**WELWYN HATFIELD BOROUGH COUNCIL
ASSISTANT DIRECTOR (PLANNING)**

DELEGATED APPLICATION

Application No: 6/2023/2081/HOUSE
Location: 21 St Josephs Green Welwyn Garden City AL7 4TT
Proposal: Erection of a single storey rear extension and single storey side extension to link up with a garage conversion, solar panels, air condition/ashp unit, new side gate, cycle store and landscaping works
Officer: Mrs Kerrie Charles

Title **Proposed Ground Floor Site Plan**

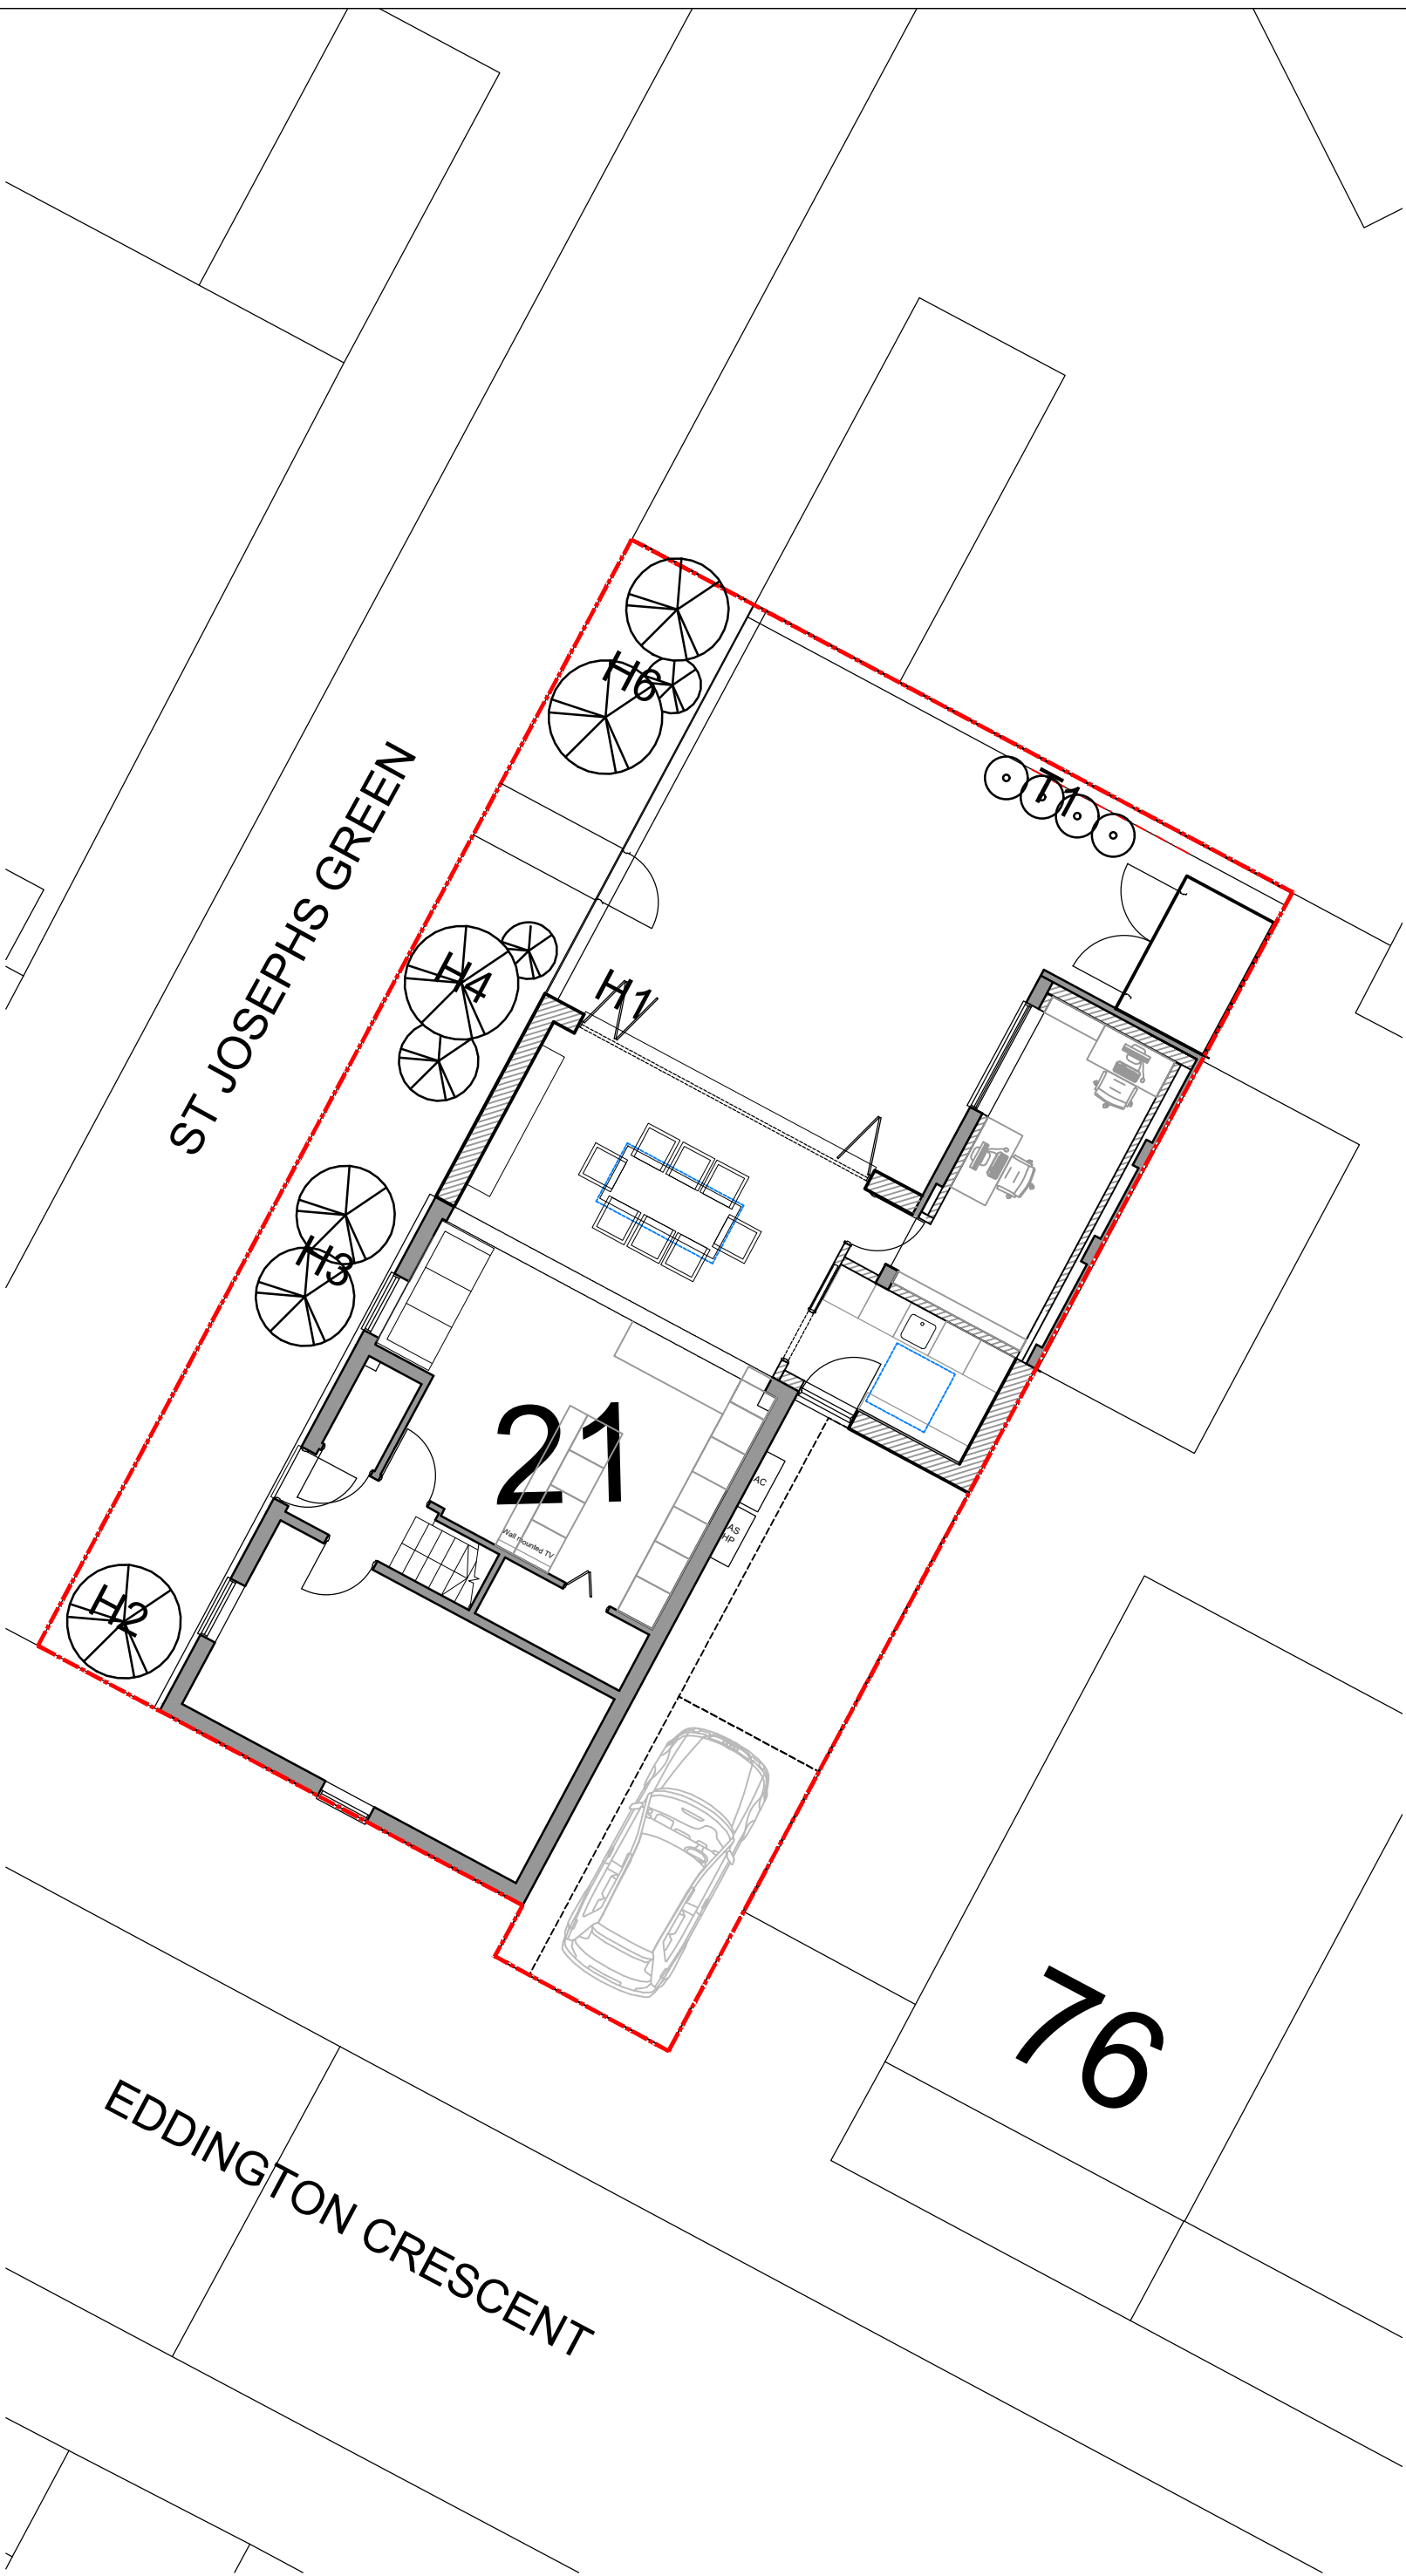
The proposal also includes the addition of a gate and a cycle shed. The proposed garden gate would be constructed of grey aluminium and several plants would be removed to facilitate access to the gate. The proposed plans also demonstrate a new cycle storage shed which would be slightly taller than the boundary wall, however it would be set back within the garden. It would also be finished with shiplap timber with a mineral felt roof. This can be secured by condition. Taking into consideration the proposal and the proposed materials to be used, the new gate and shed would not be detrimental to the character of the existing dwelling and surrounding area. The removal of some of the planting would not be unduly detrimental either as some of the plants would remain. The decking/permeable paving slabs would be limited in height and as such would not be widely visible from outside of the site, therefore no objections are raised in this regard in visual terms either.

It is not considered that the proposed development would result in a detrimental impact on the residential amenity of any neighbouring occupiers in terms of a loss of light, appearing unduly dominant or resulting in an undue impact on privacy. In terms of the hard landscaped features which comprise of decking and permeable paving slabs, these will be located in the rear garden. No elevation details have been provided. However, the applicant's agent has confirmed via email that the decking would be no more than 200mm above the natural ground level, because this is the difference between the internal floor and external ground level. A condition can be imposed securing this as the maximum height.

Off street parking would be reduced for this site following the proposed extension and garage conversion. However, two parking spaces would still be provided for the site and no further bedrooms would be created resulting from this development. A cycle storage shed is also proposed within the rear garden, which will encourage a more sustainable mode of travel. The site has sufficient off-street parking and is in a reasonably accessible location with access to services and facilities by means other than a private car, such as bus routes or cycling, therefore, on balance, no objections are raised.

3. The approved cycle shed must be finished with shiplap timber and a mineral felt roof, and the approved garden gate must be finished with grey aluminium, unless otherwise agreed in writing with the Local Planning Authority.

4. The decking/paving hereby approved shall be no greater than 200mm in height when measured from the existing ground level.

Title **Proposed Ground Floor Plan**

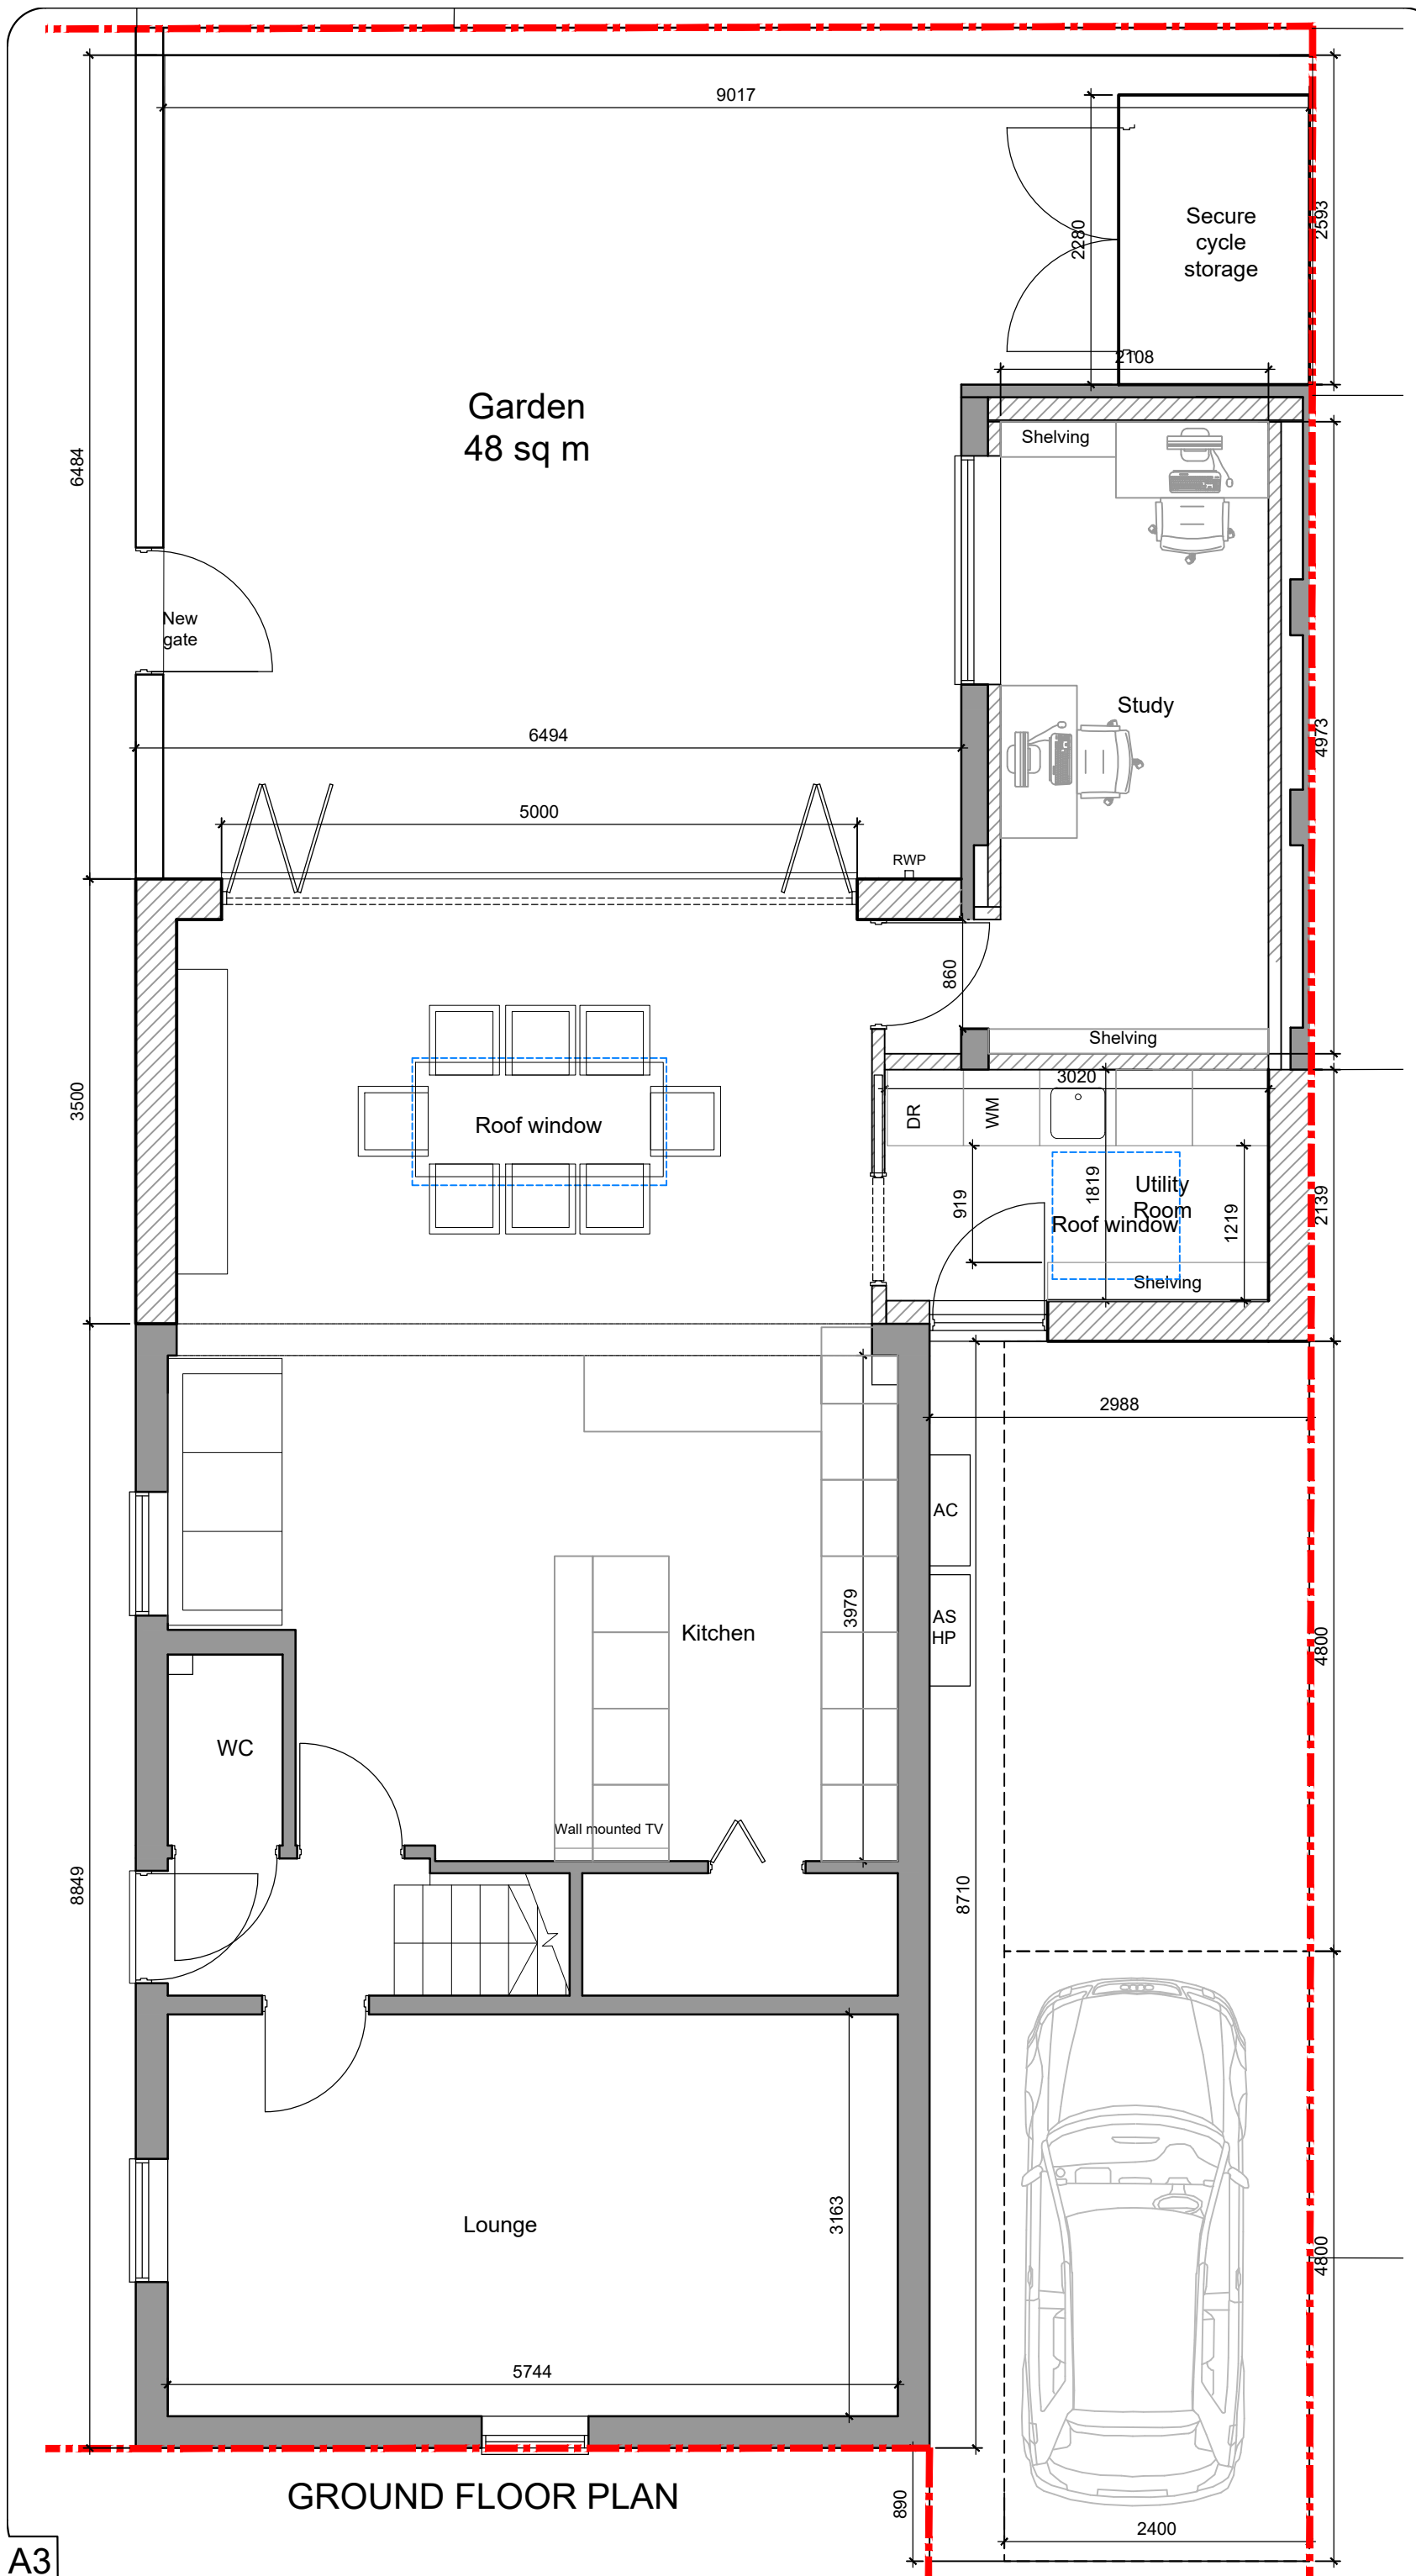
The proposed side extension would be attached to the single storey rear extension and would project outwards, in front of the existing detached garage which adjoins with the property next door. The existing garage provides a sense of symmetry which is aesthetically pleasing. The proposed single storey side extension with a flat roof would obscure parts of the garage, unbalancing the symmetrical appearance. However, it is noted that this would only be visible from specific public vantage points within the street scene, which face directly towards this area of the site. This is because the application dwelling and the adjoining dwelling would largely obscure this part of the site from other viewpoints. In addition, the extension would be built close to the rear building line of the rear elevation of the dwelling and as such it would be considerably set back from the elevation which faces Eddington Crescent. For these reasons, it is considered that this aspect of the proposal would, on balance, be acceptable.

Title **Proposed Elevation - Front and Rear**

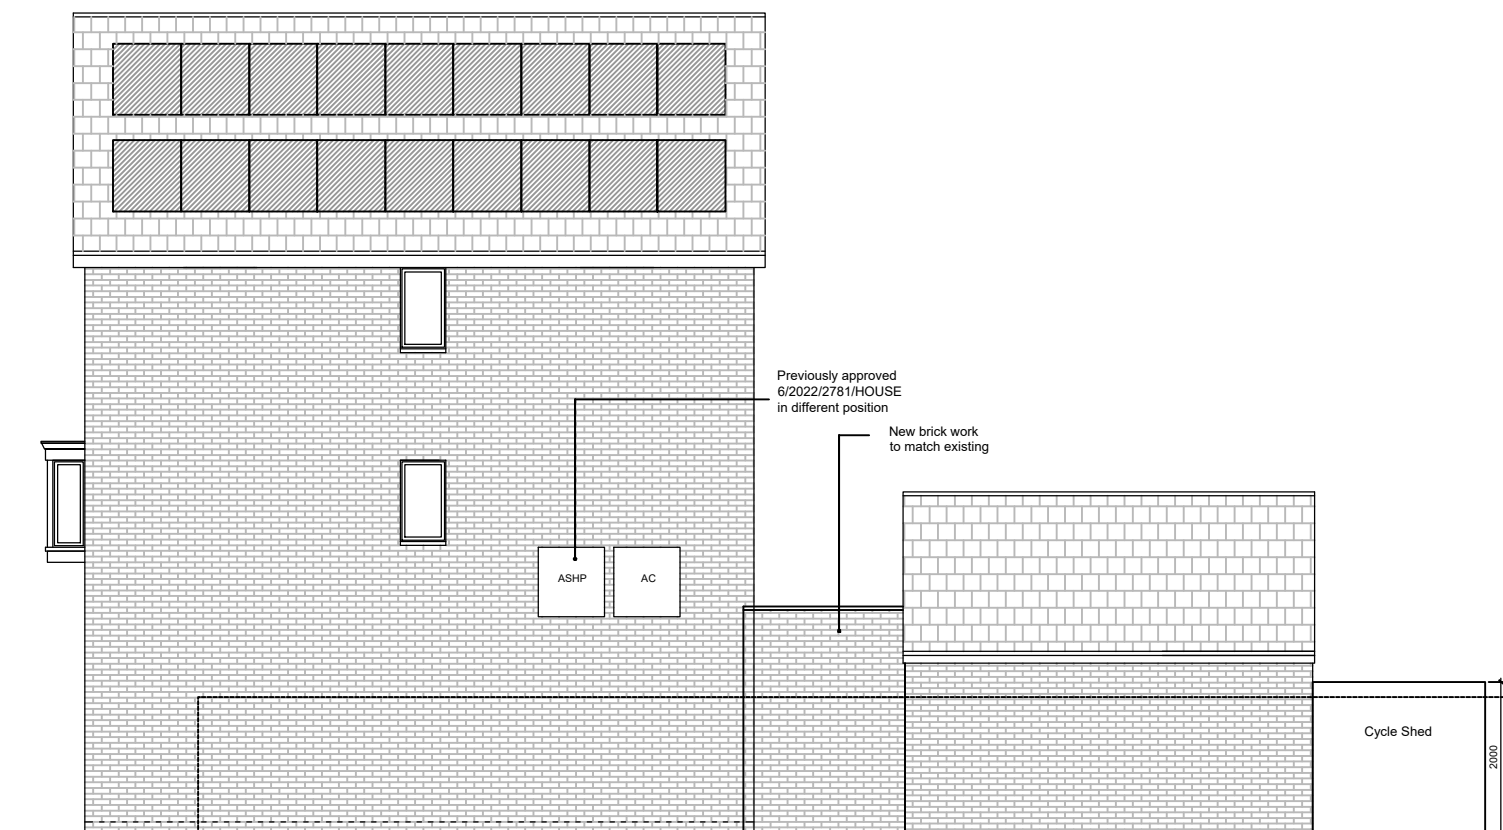
The revised scheme would increase the bulk and mass at the rear of the dwelling which would be visible within the streetscene due to the position of the dwelling and the shared garage with the adjoining property. The amenity space within the rear garden would be reduced, however it is considered that on balance, a functional and useable garden would remain. Taking into consideration the rear part of the proposed extension being single storey and being constructed with a flat roof and matching materials, on balance the proposed works would be considered acceptable in this regard.

The air conditioning units and air source heat pump would be visible from the road but would be of a modest scale that would not detract from the character of the surrounding area and are therefore considered acceptable.

1. The brickwork, roof tile, bond, mortar, windows, detailing, guttering, soffits and other external decorations of the approved extensions and alterations must match the existing dwelling in relation to colour and texture.
